OXFORDSHIRE COUNTY COUNCIL'S RESPONSE TO CONSULTATION ON THE FOLLOWING DEVELOPMENT PROPOSAL

Application no: 17/00216/F

Proposal: RETROSPECTIVE - Proposed temporary haul road (construction access) to serve part of the mixed use development scheme at South West Bicester (Kingsmere), granted Outline Planning Permission under reference 06/00967/OUT (previous approval ref: 10/01027/F and 13/01446/F)

Transport

PROJECT No:	DRAWING No:	REV:
11011903	1903/KM2/SK/02	J

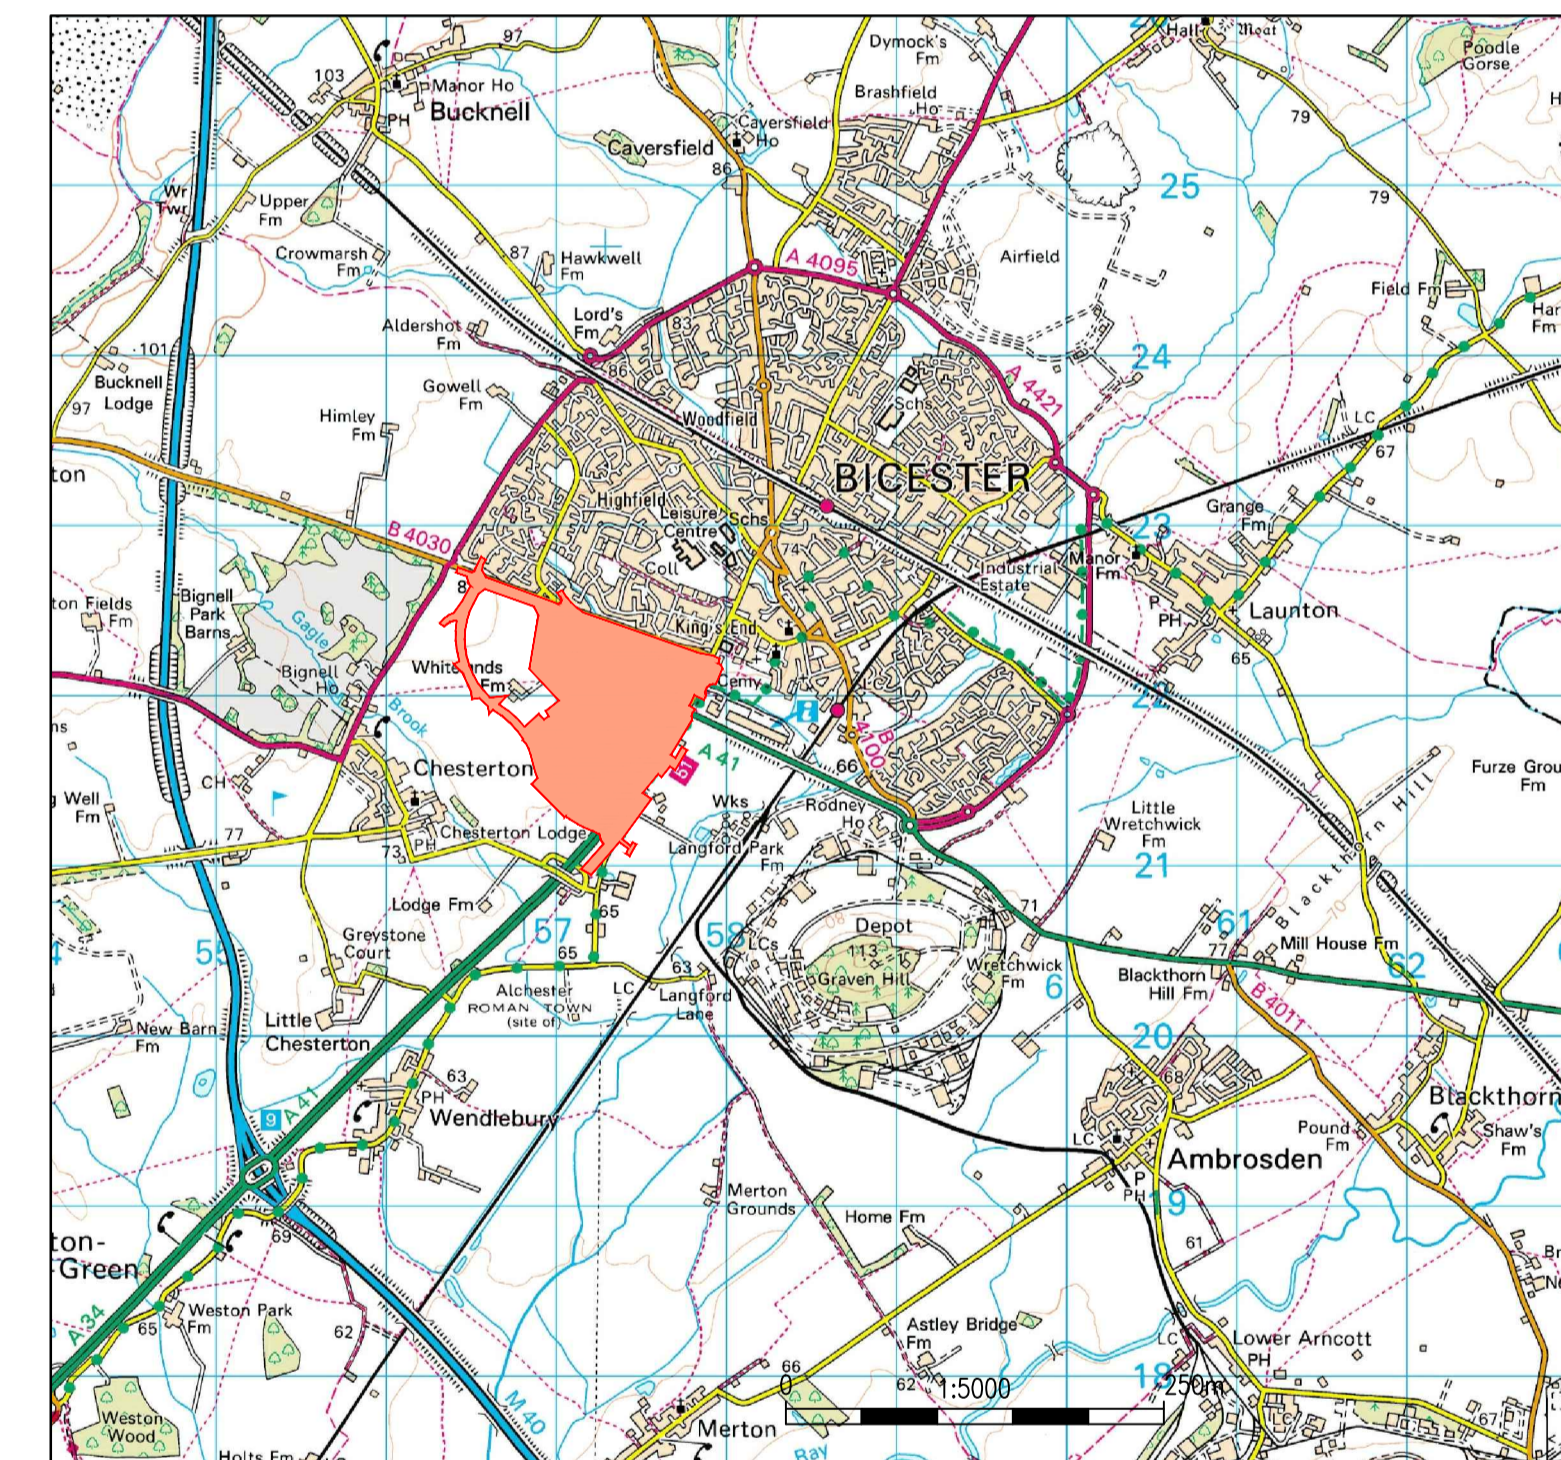
After the temporary 3 years duration hereby approved, the existing haul access onto the Kingsmere site as shown in plan 1903/KM2/SK/02, shall be permanently stopped up and reinstated as was, and shall not be used by any vehicular traffic whatsoever.

TITLE: **TEMPORARY HAUL ROAD**

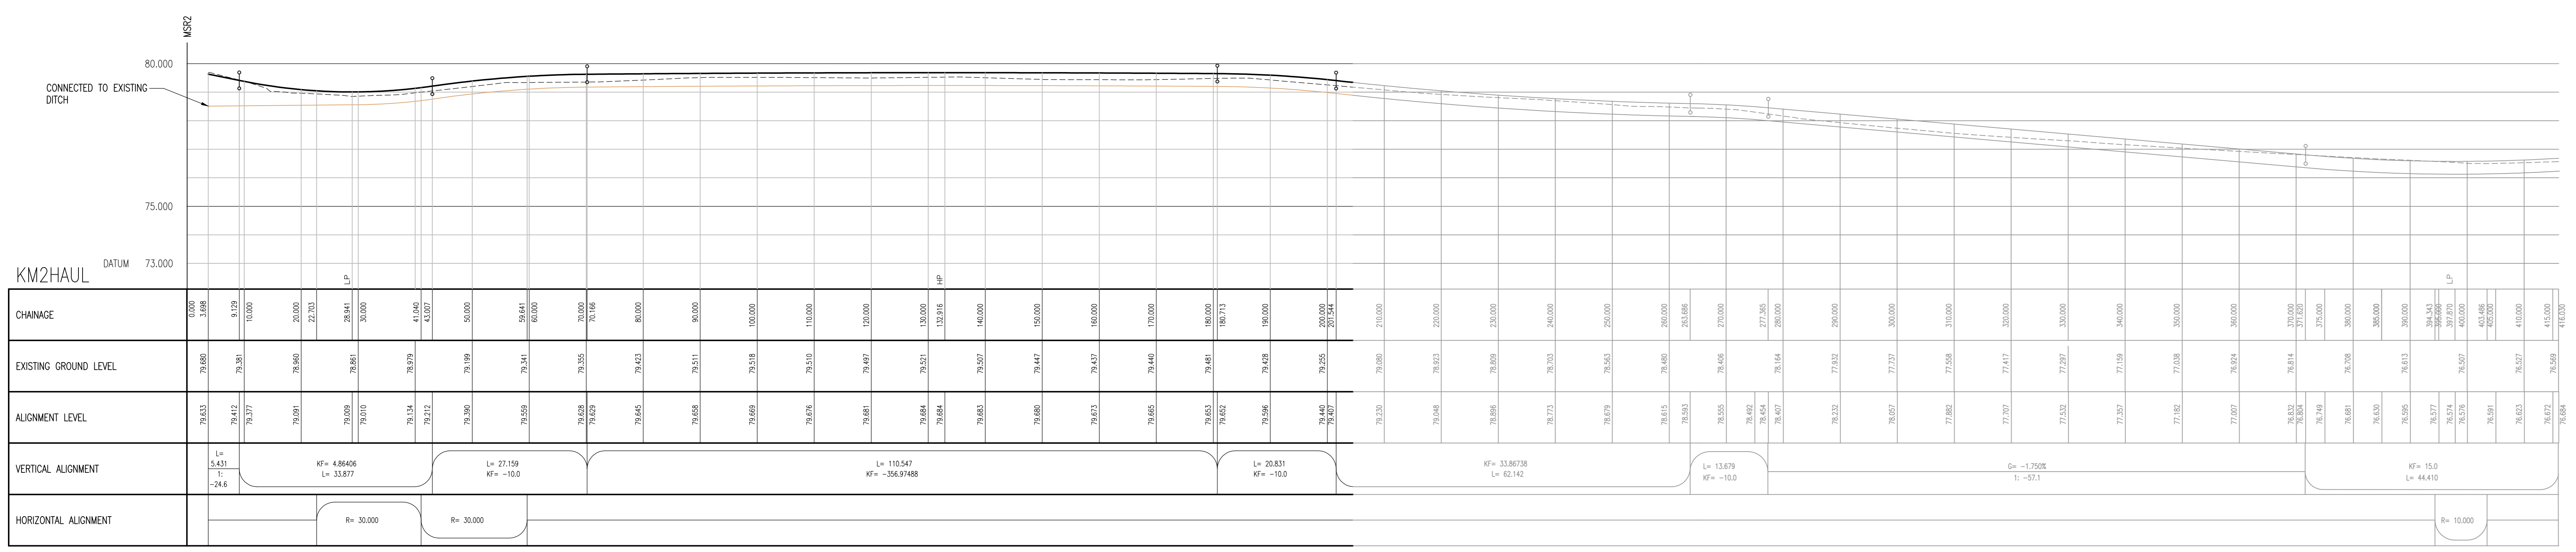
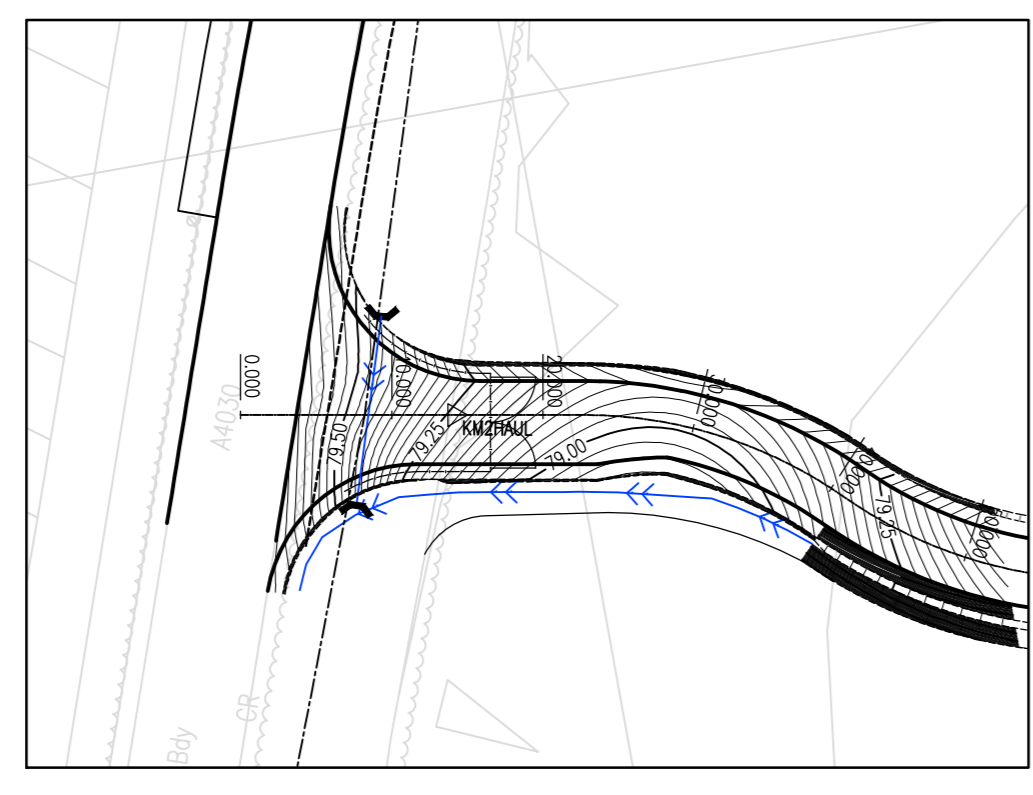
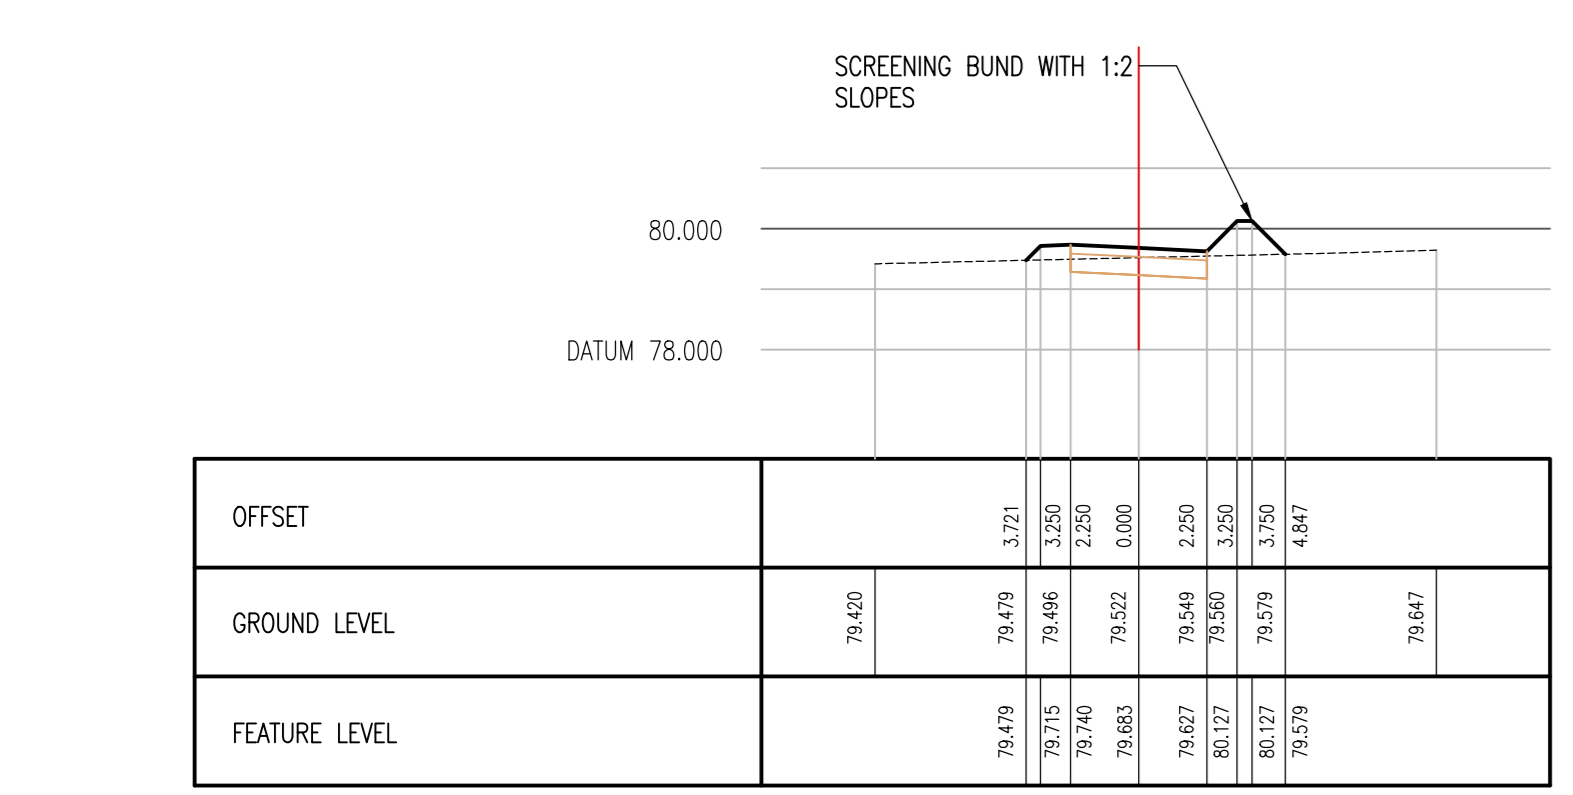
The access is already in situ and comes off Middleton Stoney Road. It currently has visibility splays of 4.5m x 160m, which are adequate for a road with speeds up to 50mph, according to DMRB.

The access onto Middleton Stoney Road (bellmouth) has been designed to ensure that heavy goods vehicles entering and leaving the haul road do not affect traffic safety on Middleton Stoney Road, with construction HGVs being able to pass each other at the entrance to the access road.

The vision splays shall not be obstructed by any object, structure, planting or other material of a height exceeding 0.9m measured from the carriageway level.
